Re: Application to Modify a Development
Reference Number LOC 9371
Address: Sydney International Convention & Exhibition Centre Precinct

- **SICEEP - MCD PDA - S96 Mod 2 - Modify Darling Square, Stage 1**
Concept Proposal Request for Landowner Consent

**Re: SSD 7021 MIXED USE COMMUNITY AND RETAIL BUILDING AND PUBLIC SQUARE
WITHIN THE NORTH PLOT (DARLING SQUARE, HAYMARKET)**

NORTH PLOT AND DARLING SQUARE
FURNITURE PLAN

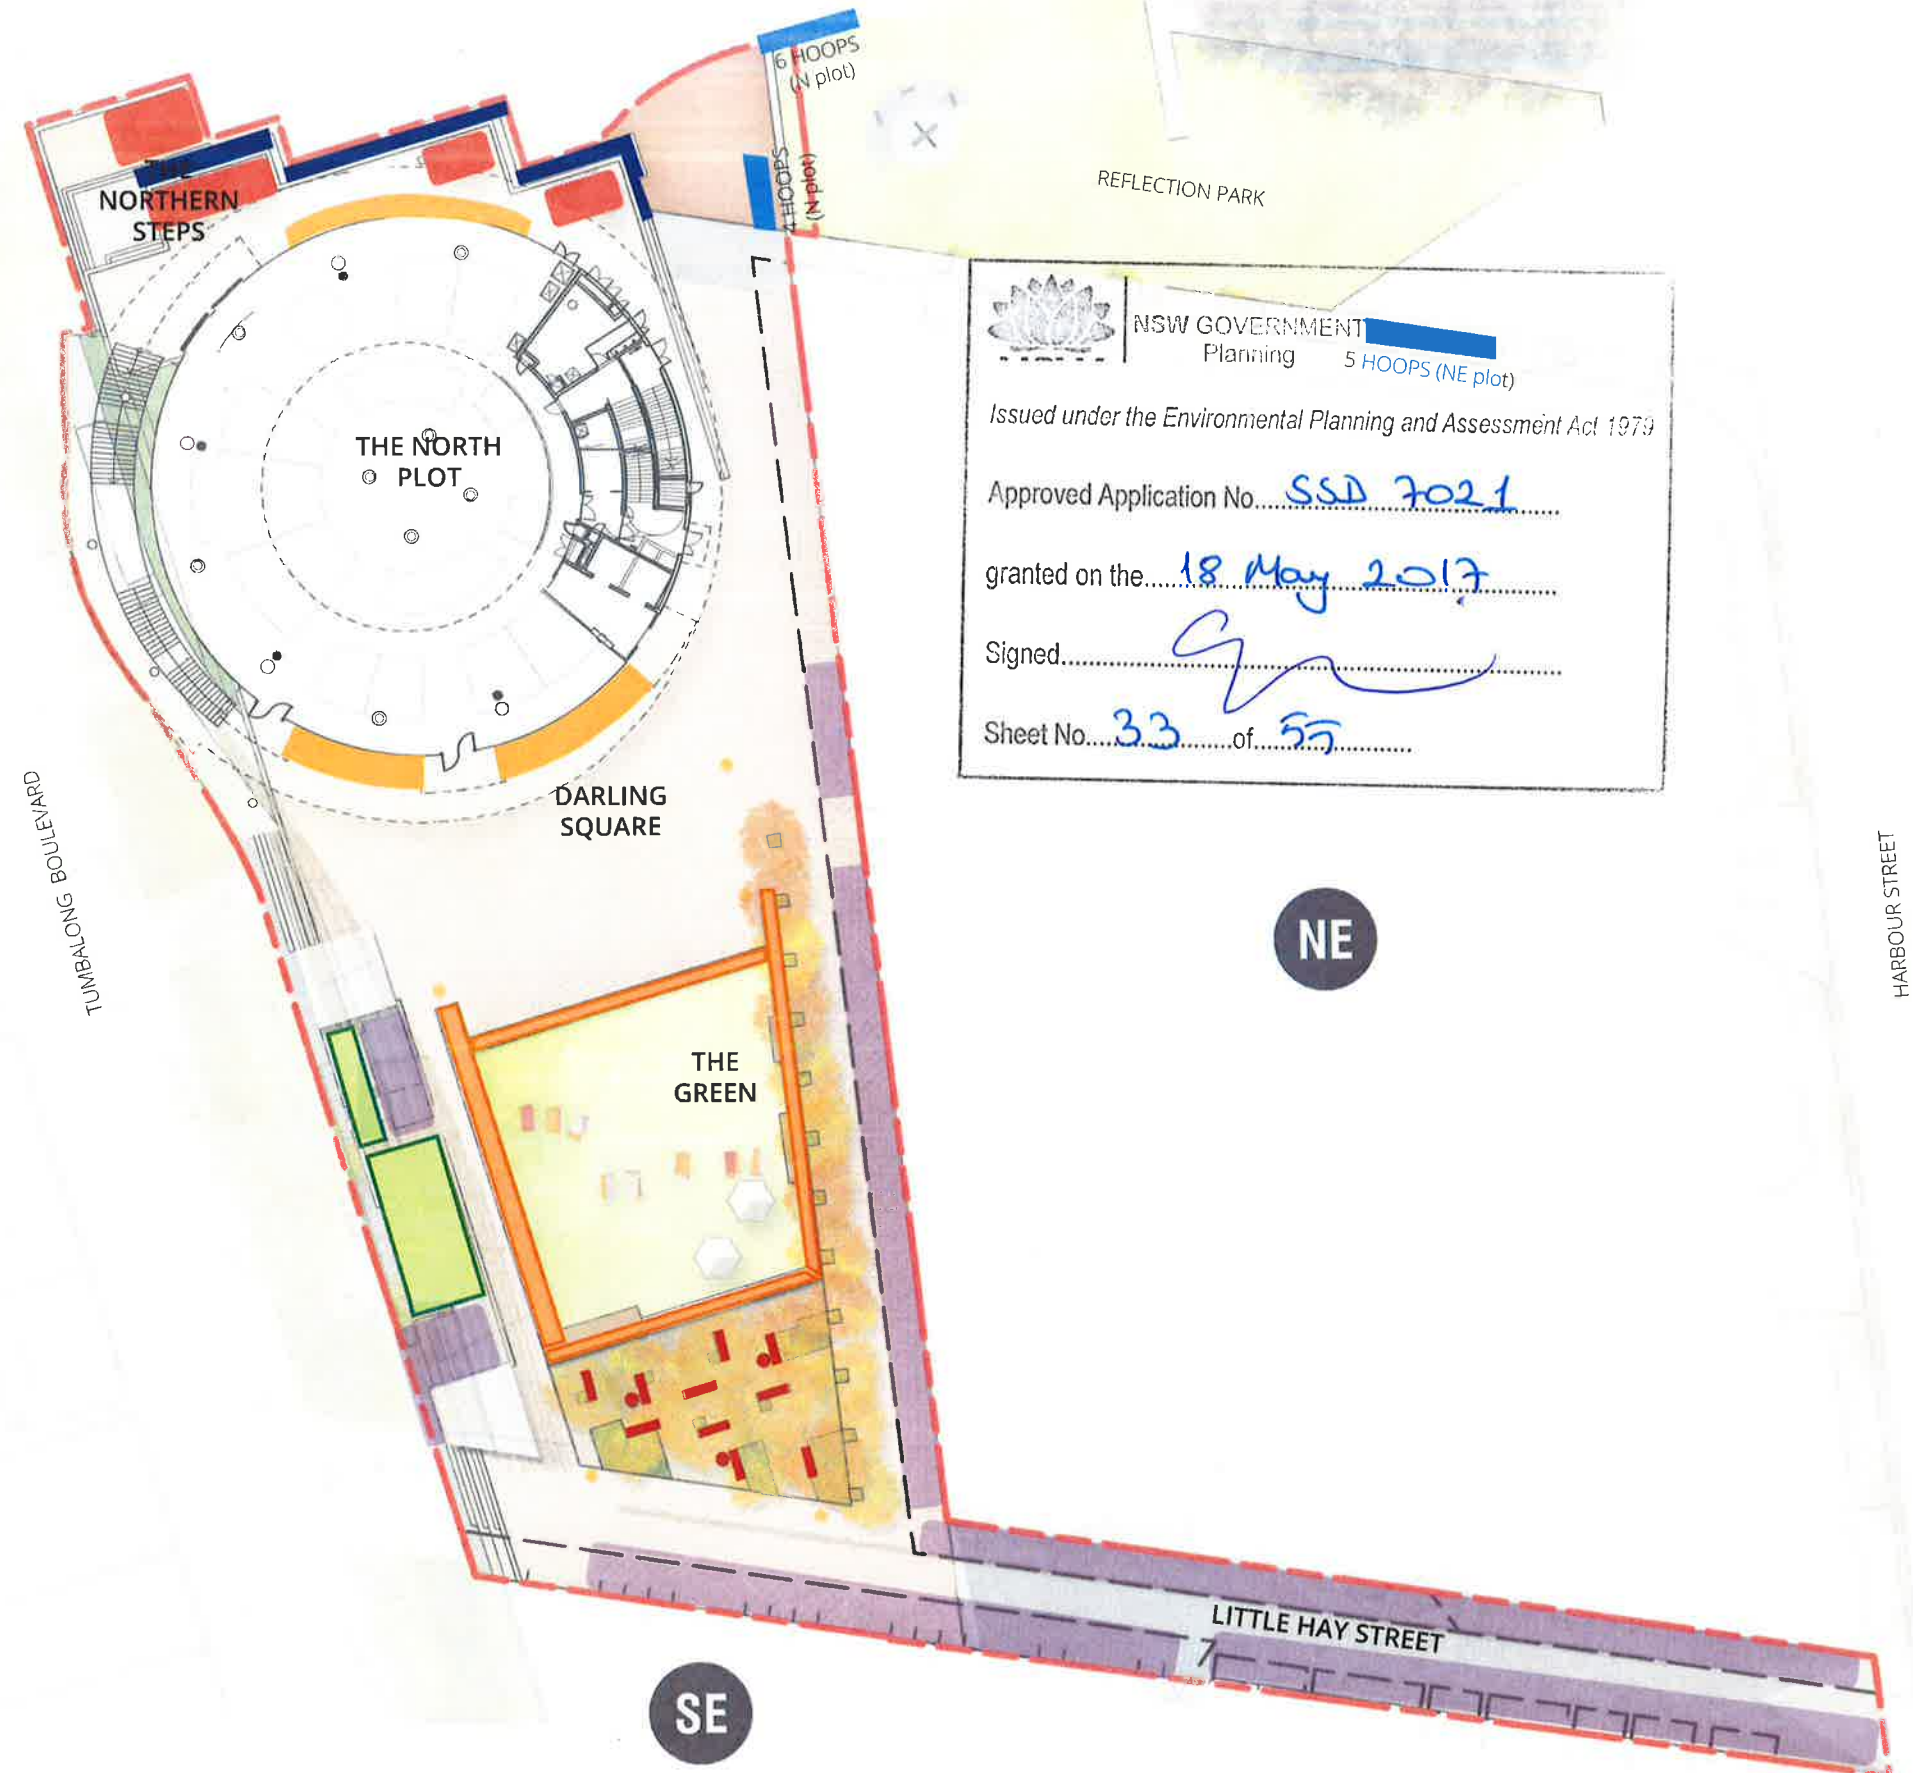
In addition, two permanent retail 'pods' are proposed to aid activation to both the Square and the Boulevard. Although activation of the public domain is supported, it is considered that the planned retail component on the ground floor of the Exchange Building, coupled with the organised markets and outdoor events on Haymarket Square will provide adequate opportunities for activation of the public domain. Accordingly, the introduction of retail pods on Haymarket Square is considered excessive and creates unnecessary visual clutter.

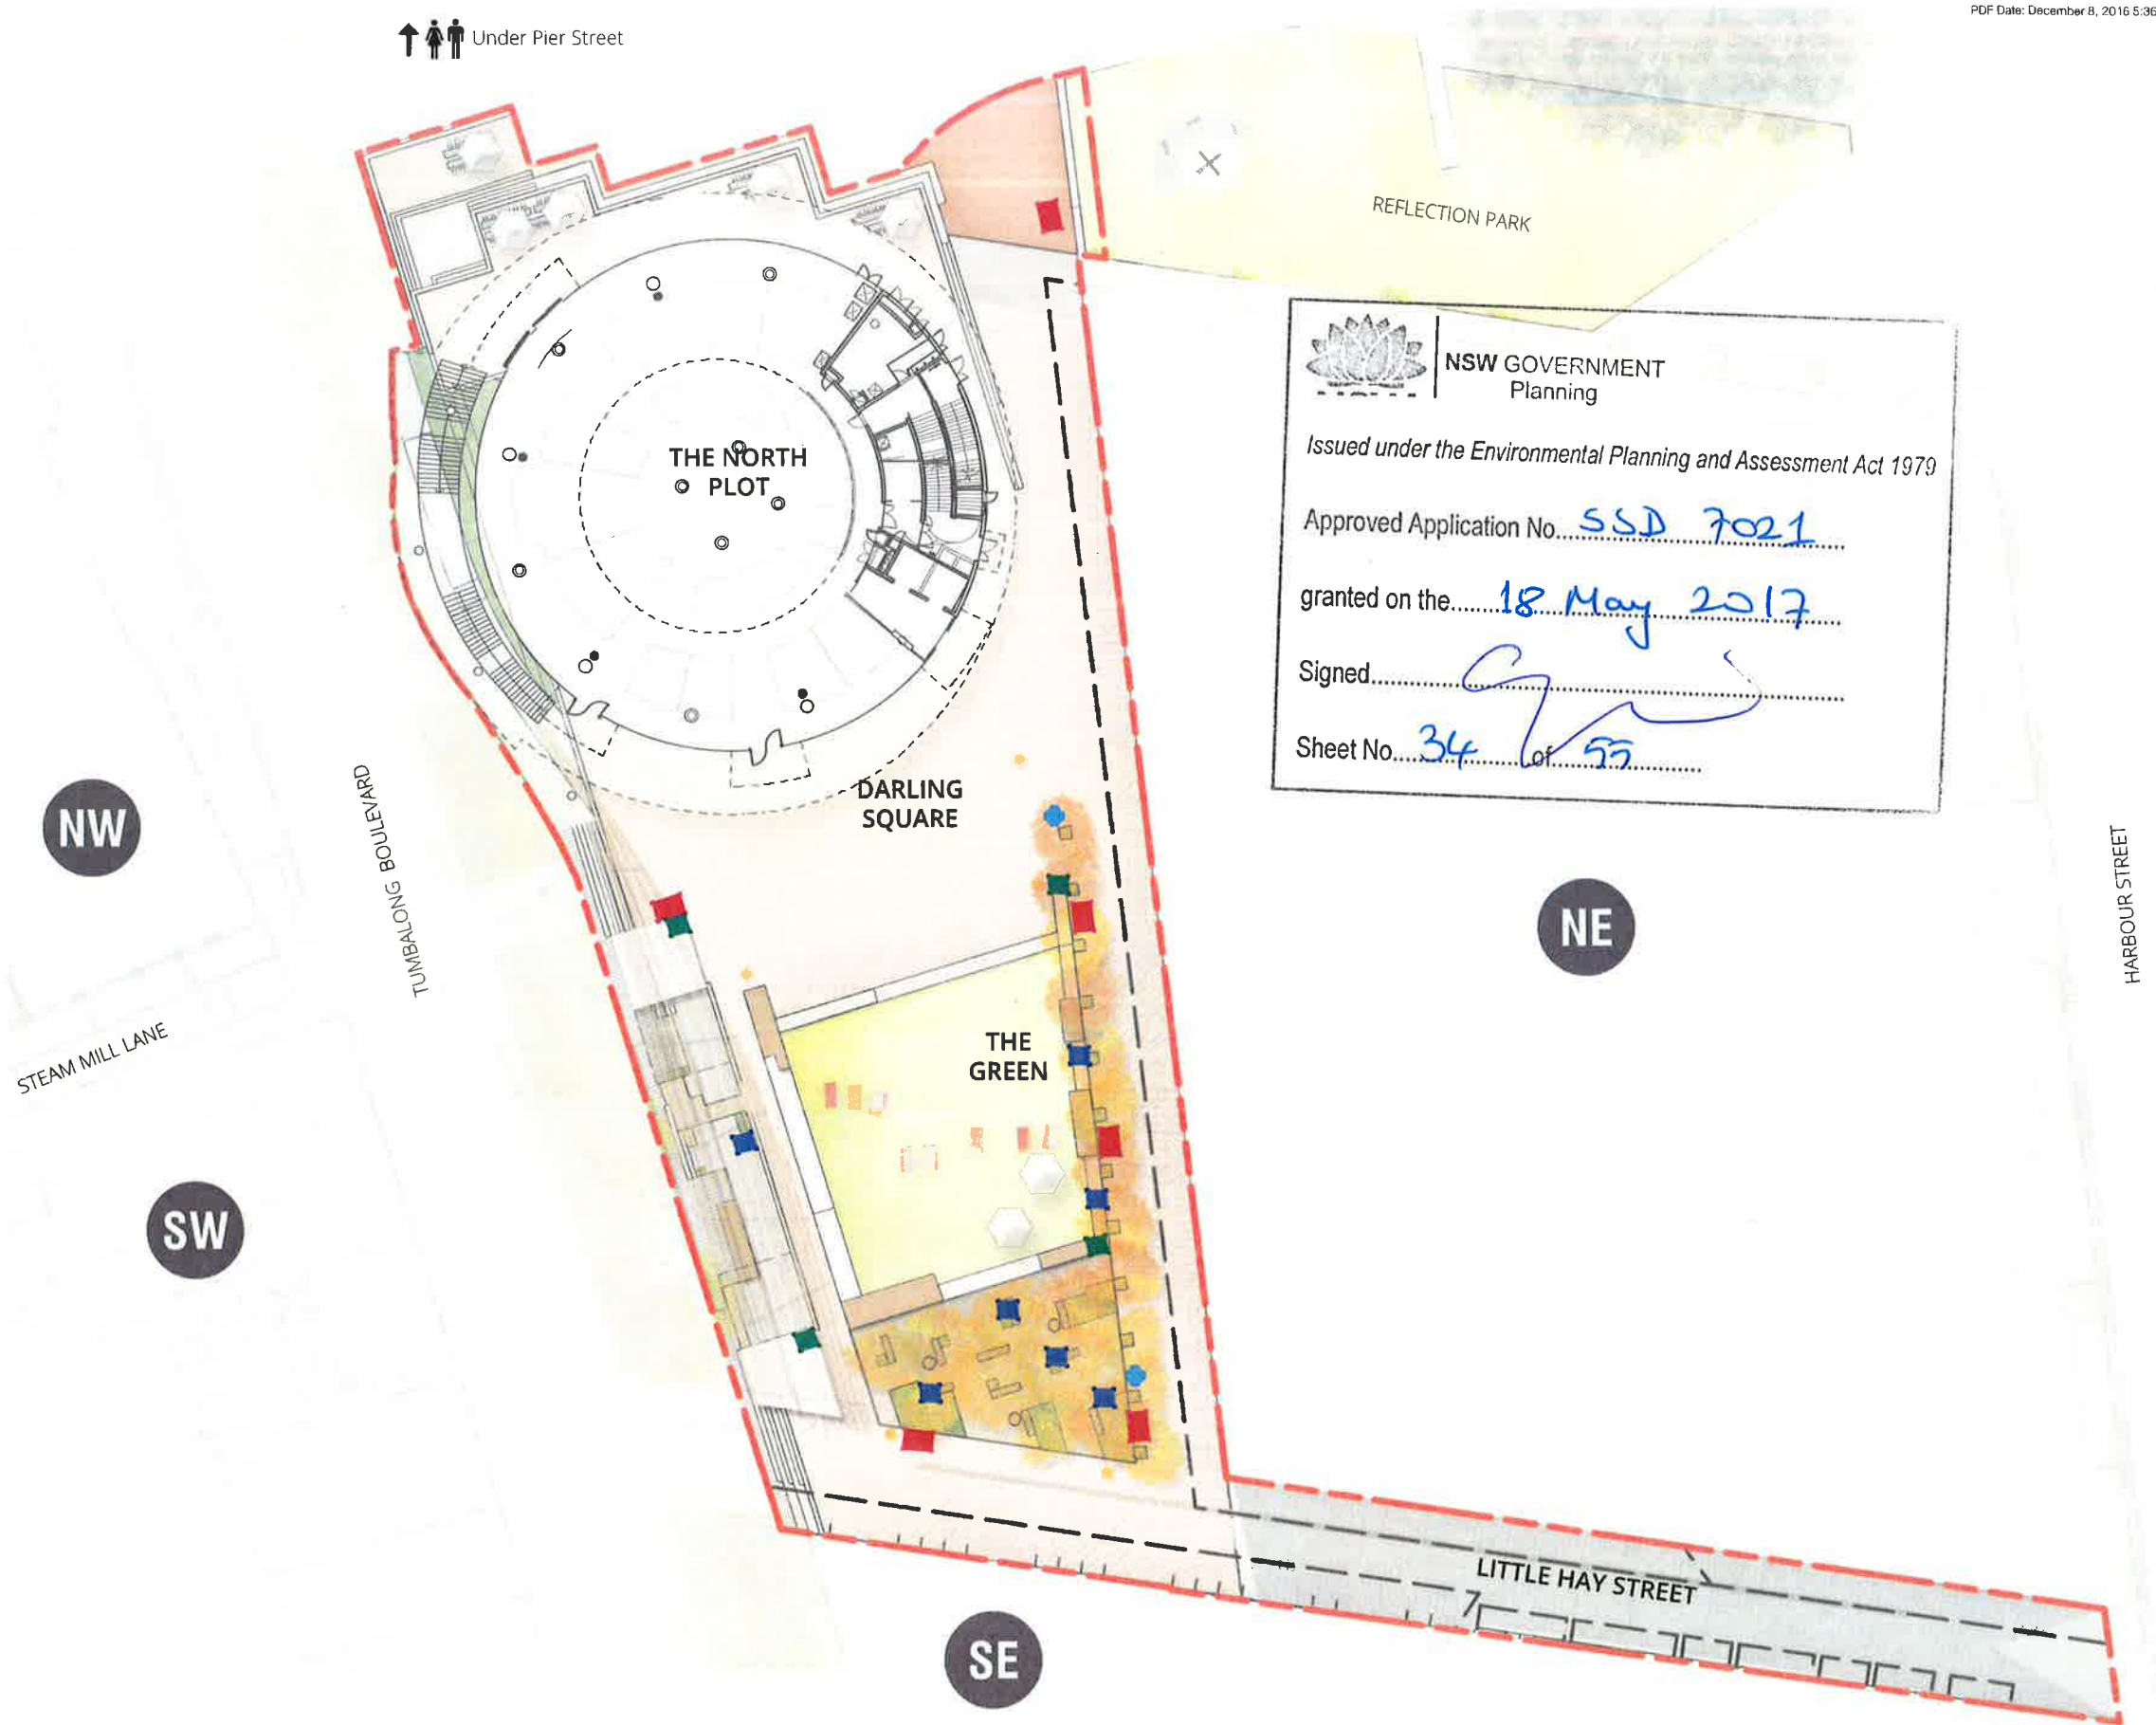
The Authority notes that the majority of loading and servicing arrangements for the Darling Exchange Building and Haymarket Square are proposed from a series of new loading areas located on and adjacent to the public domain area of the North Plot.

The proposed loading and servicing arrangements are considered contrary to what was envisaged in the early concept master plan (Stage 1) where servicing arrangements for the North Plot were to take place predominantly from the North East Plot.

The Authority considers that the proposed loading areas C, D, F would undermine the pedestrian character and amenity of the public domain around the Darling Exchange and Haymarket Square and does not support their inclusion. These new arrangements may also pose unacceptable ongoing management obligations on the future entity that may be responsible for these public spaces.

Therefore, in the Authority's opinion the loading and servicing arrangements for the North Plot should be confined to the adjoining North East Plot as envisaged under the earlier Stage 1 approval.
